4303 Pinehurst Circle
Colorado Springs, CO 80908

SITE DEVELOPMENT PLAN

C1.1-DP

C1.1-DP

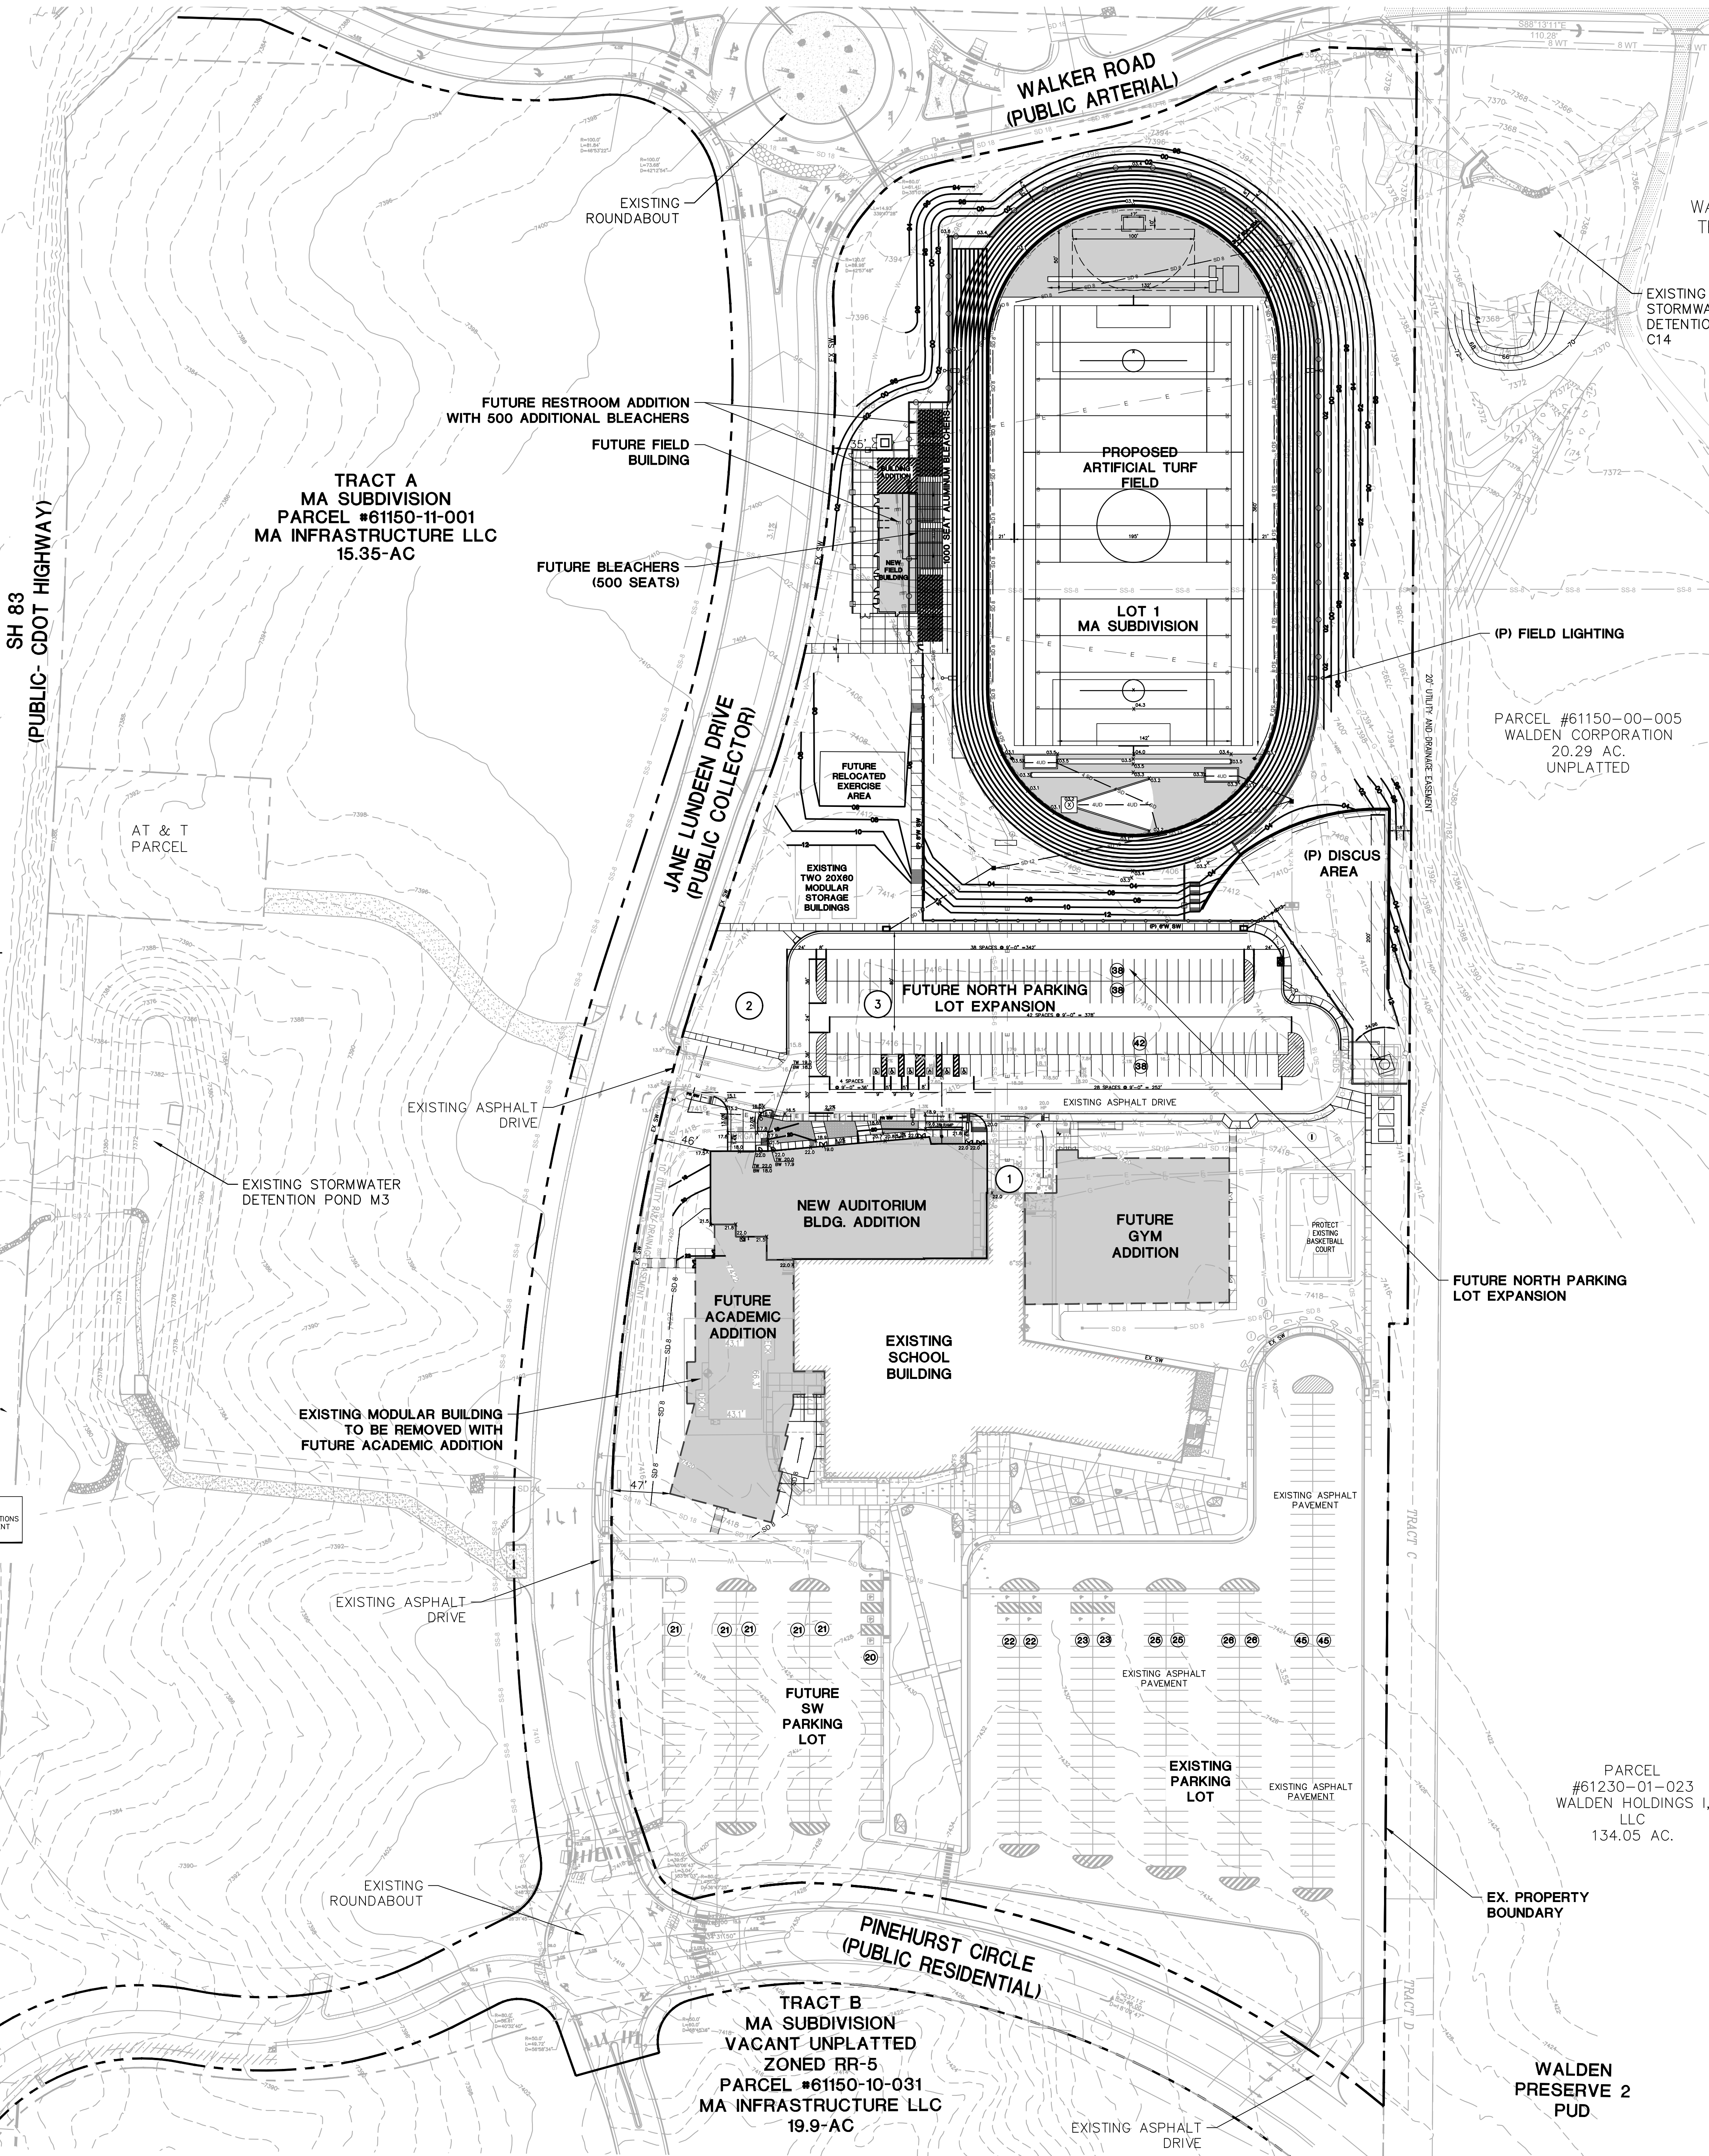
1 TRASH DUMPSTERS — Are the dumpsters screened?

Please see Monument Fire EDARP comment dated 8/7/2026.

Add existing and proposed hydrants per Monument Fire EDARP comment.

Add PCD File No. PPR2621
